10461 Hook Lane, Pagham

Technical Note 4 Rv01: Response to LLFA Comments on RMA

31st March 2021

Title.
TOPOGRAPHICAL SURVEY
LAND AT PAGHAM, PAGHAM ROAD
PAGHAM
WEST SUSSEX
PO21 3PD

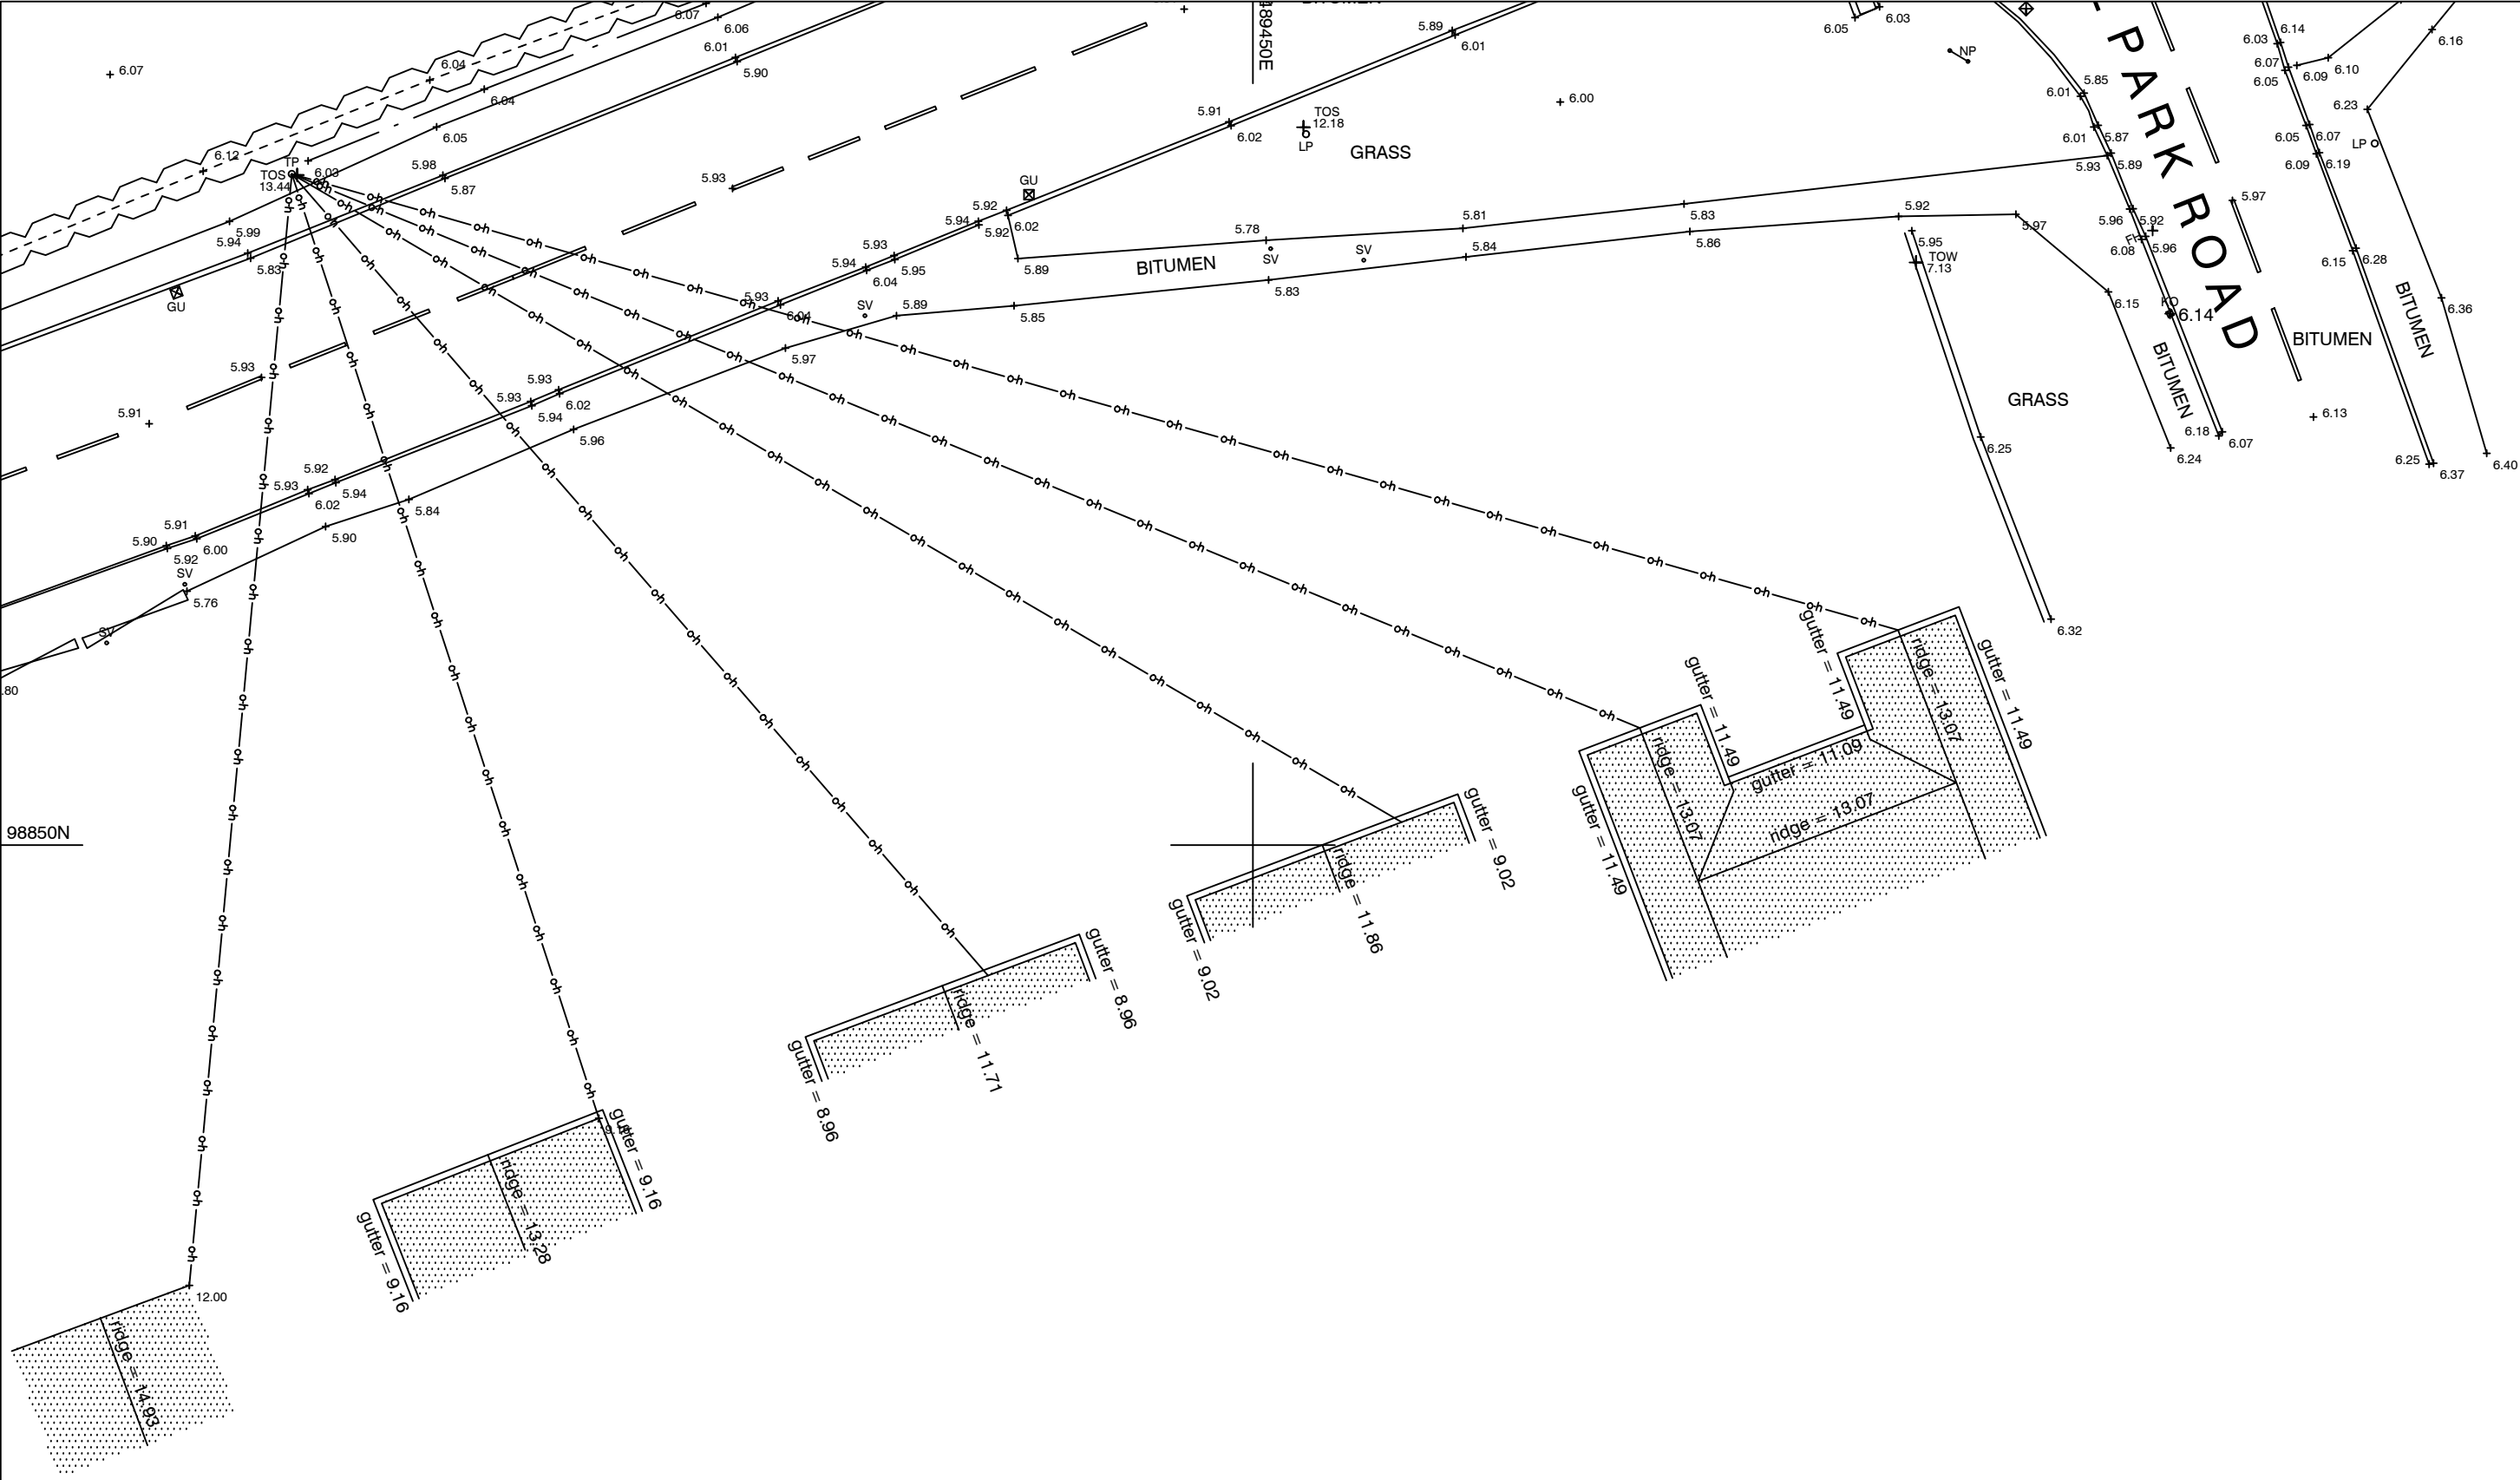
2.3 We note that there are a lack of levels provided for many of the existing watercourses. These levels must be provided to evidence if the proposed invert levels of structures and connections are achievable.

2.3.1.1 *There are large areas of watercourse which have not been surveyed due to overgrown vegetation. Of the areas that have been surveyed no pipe invert levels have been provided. Please can further survey information be supplied. It would also be beneficial to get the topo in .dwg format if possible, as it isn't the easiest zooming in so far on a pdf, and then waiting for it to load when trying to move across the drawing. If not, as a minimum a key plan should be provided on all sheets to identify which parts of the site are covered by each topographic survey drawing sheet.*

2.3.1 Please refer to the topographical survey appended to this note for further details of the existing watercourse.

CAD file supplied.

SECTIONS
LAND AT PAGHAM, PAGHAM ROAD
PAGHAM
WEST SUSSEX
PO21 3PD

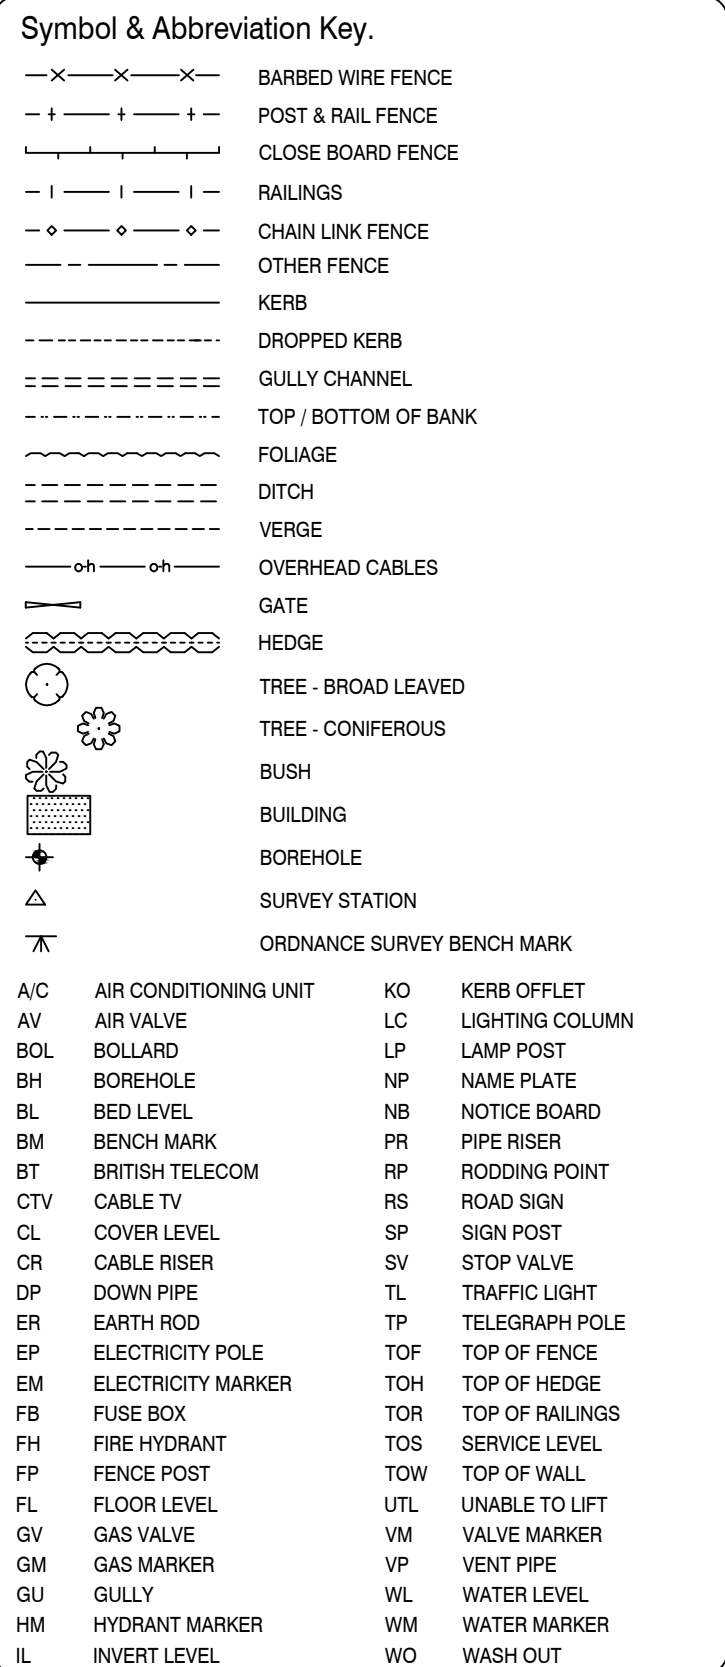
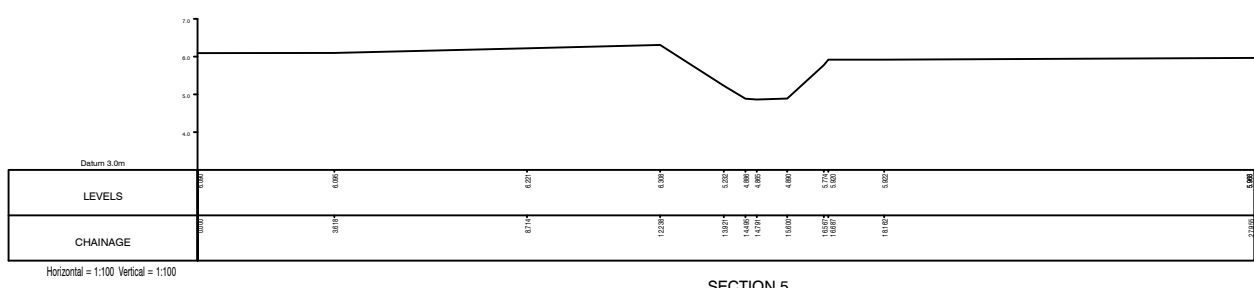
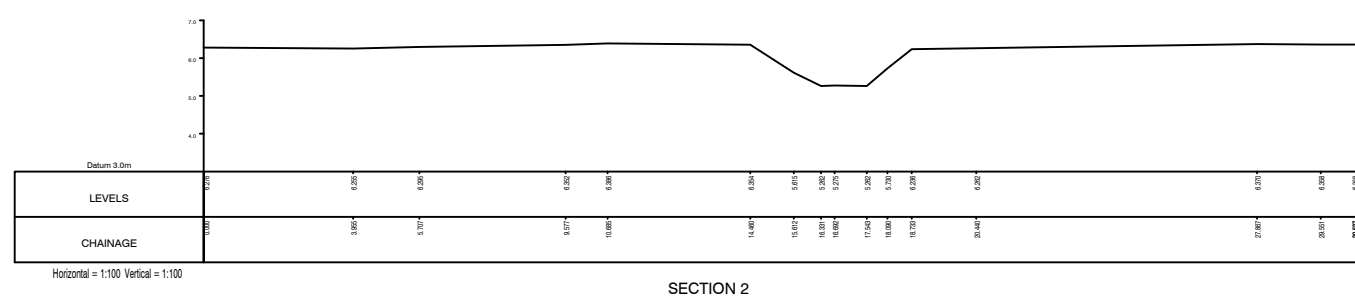
2.5 If the proposed swale referenced in point 2 above is proposed to replace the watercourse we will require a long section of the proposed swale to be provided to evidence if the proposals to divert the watercourse are acceptable, and therefore if the proposed site layout is acceptable. Levels of upstream and downstream watercourses must be provided

2.5.1.1 *Your proposals for the swale show a downstream invert level of 3.29. But on the topographic survey levels are currently 3.78-3.66 in this area. Without knowing the culvert invert levels in the area and the downstream watercourse levels it is not possible to know whether this is achievable in practice*

- 2.5.1.4** *It would be useful to have a long section of the existing watercourse. So that comparisons of length of watercourse and falls can be completed more easily.*

2.5.1 Please refer to the appendix for a long section of the diverted watercourse. We have endeavoured to mirror the existing longitudinal profile as far as reasonably practicable.

We are trying to replicate the existing situation as closely as possible and the existing information we have suggests this is the case. It has also been noted that the outfall to the east eventually flows north along Hook Lane and Sefter Road back to Sefter Cottage, therefore ultimately outfalls to the same point. As shown on the Extract from ADC Mapping dated 02 November 2020.

Long section prepared and appended.
